APPENDIX Y

AVIATEQ INTERNATIONAL LIMITED REPORT (OCTOBER 2018)

Proposed Hornsea Three Offshore Wind Farm

Date: October 2018

Figure 8.8: Aviation flights within 9 nm of Hornsea Three during October 2017.

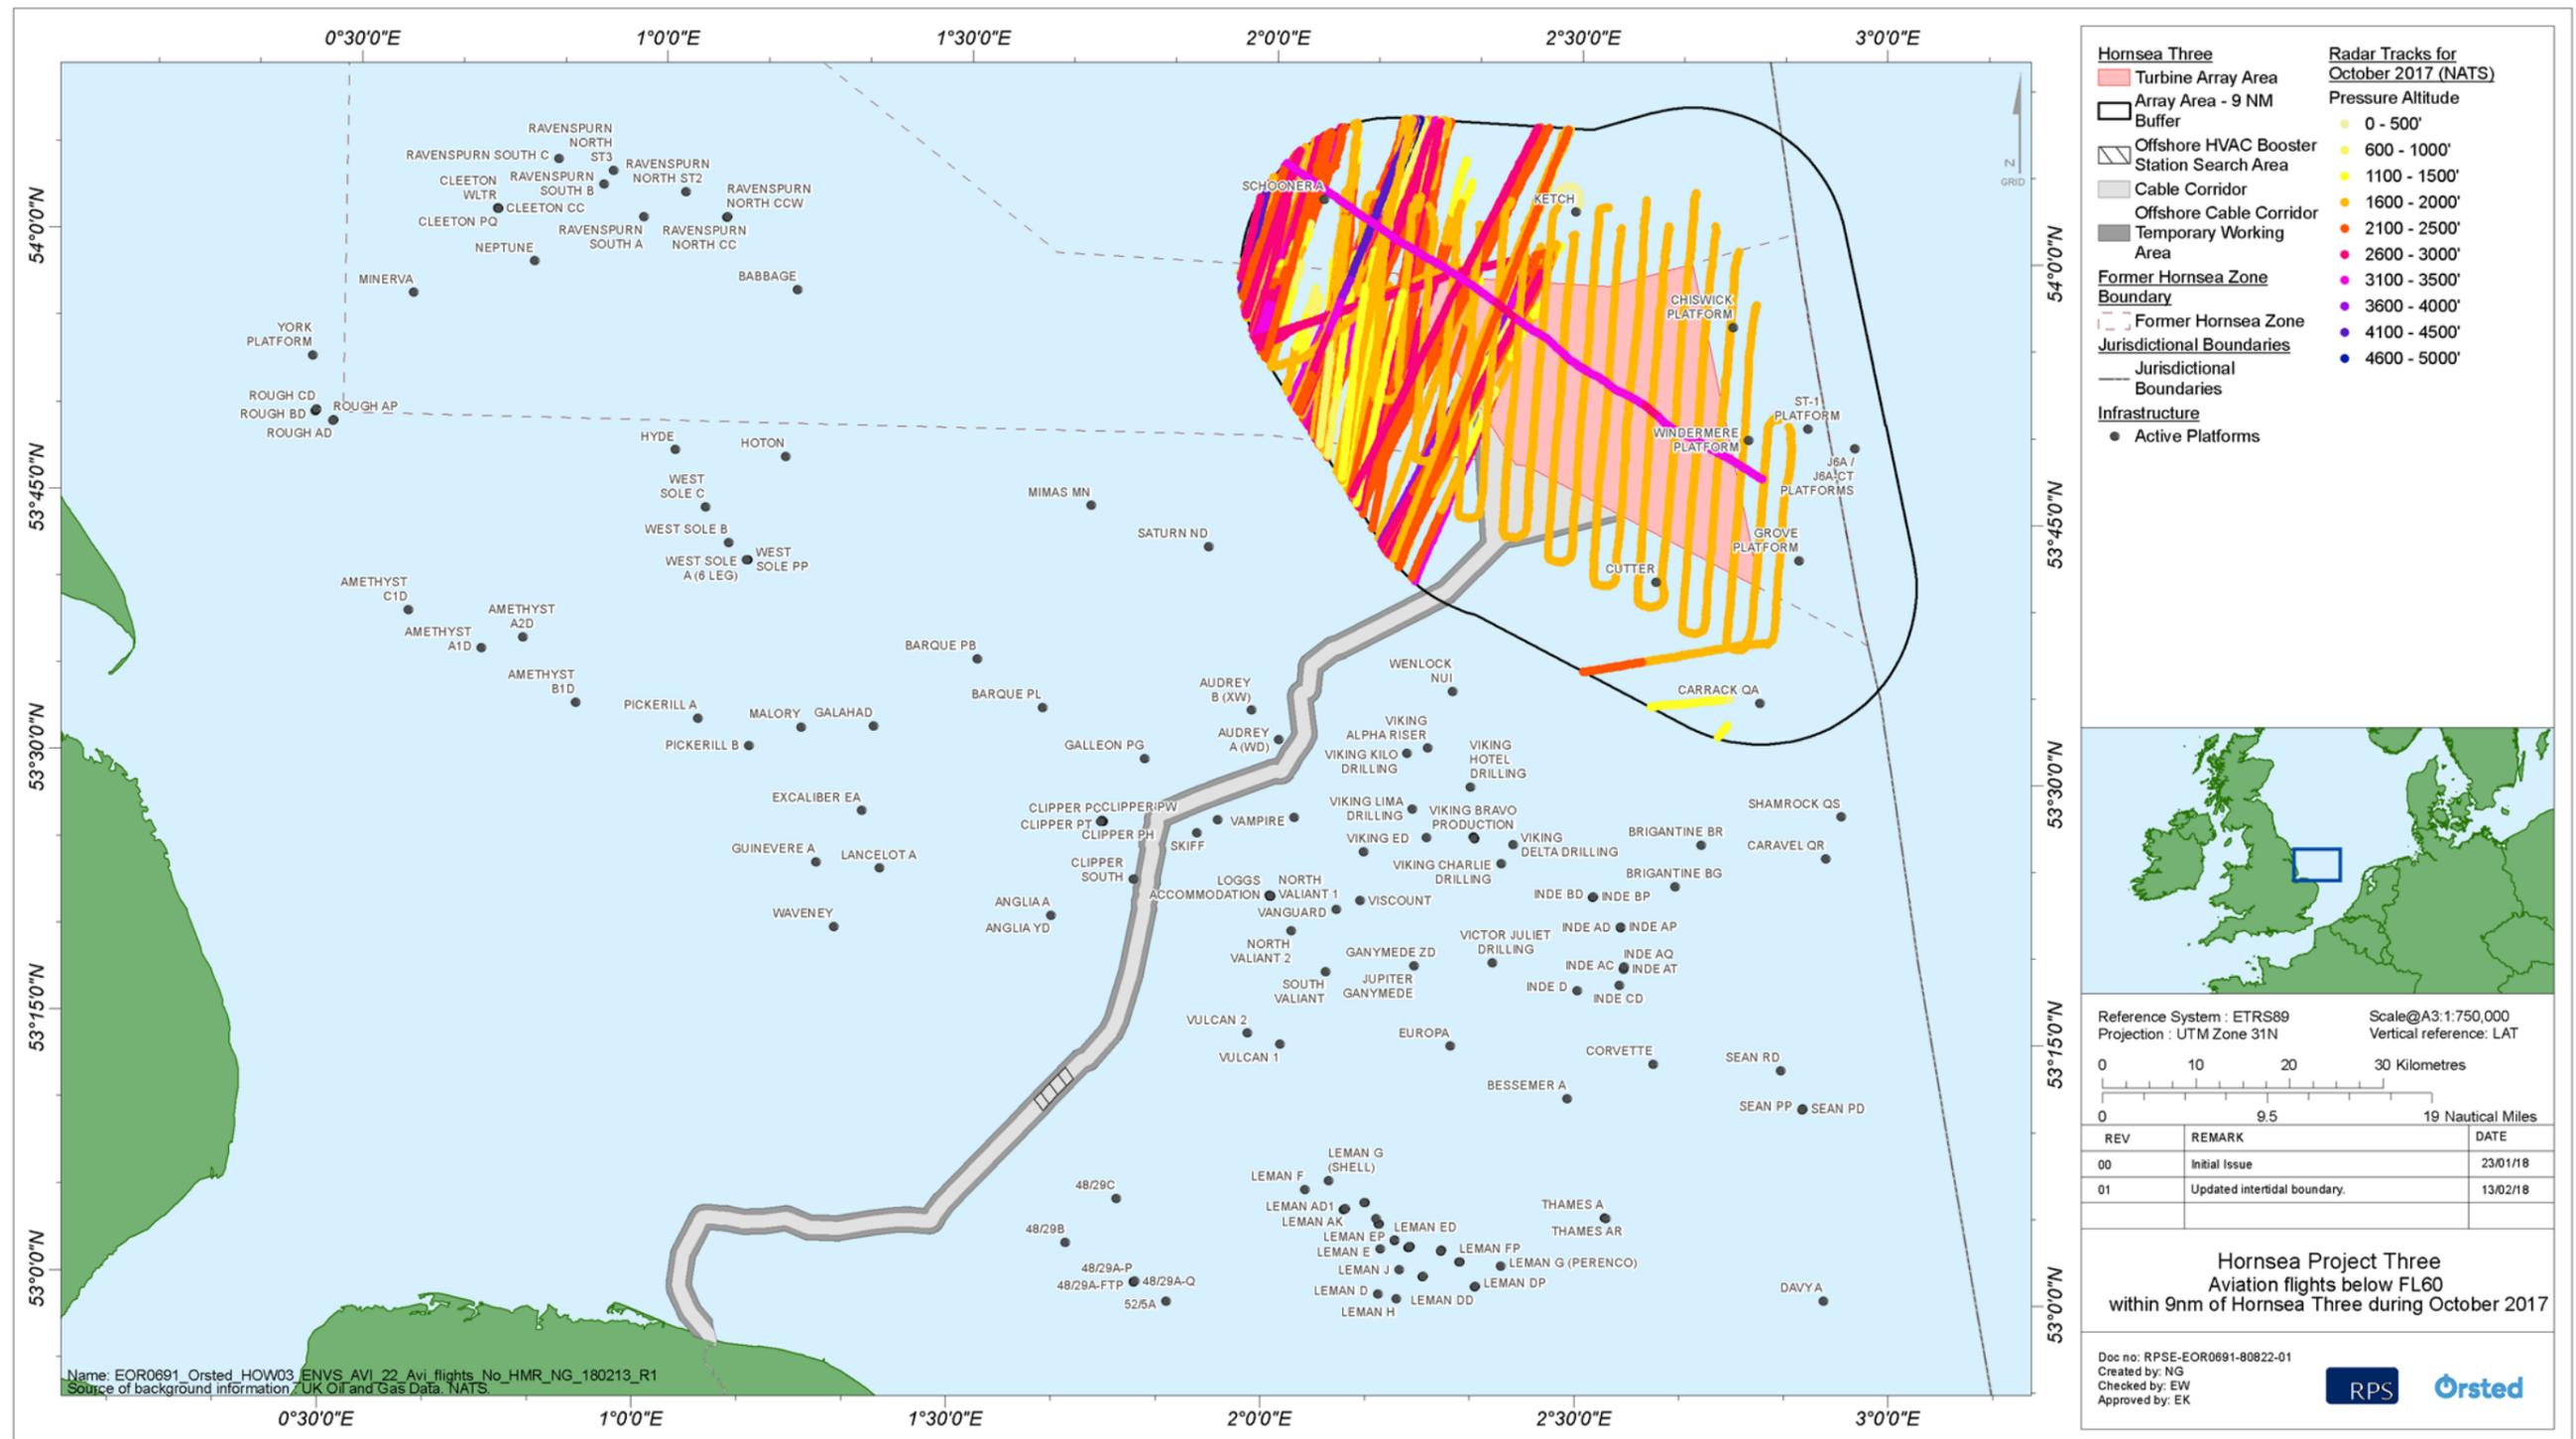
9.1 Reference Figure 8.8, Section 8.11, Chapter 8.11.2 of the ES and Slide #15 in the Hornsea Project Three Consultation Meeting held in Aberdeen, 10/10/2018 Power Point presentation. These figures depict aviation flights within 9 nautical miles of Hornsea Three during October 2017. They do not show the point of origin or the point of termination of the flights with Slide #15 stating that *no flights shown to Chiswick platform, J6A platform or Grove platform from Norwich or Humberside.*

9.2 The information is one year old and not representative of current activity. Records provided by Spirit’s current helicopter operator indicate that in 2018 up to the 22nd October 2018 there were 67 landings on the Chiswick platform from flights originating from Norwich and one to the J6A. The number of landings is quoted because the number of flights would be misleading due to multiple sector flights to Chiswick, Grove and J6A. In addition, these figures may not be representative of future demand as Spirit Energy may adjust the frequency of flights and subsequent landings in order to cater for increased or decreased demand. At the time of writing, for example, regular flights were being carried out for Spirit Energy to the Noble Hans Deul rig which was on project over the Chiswick location.
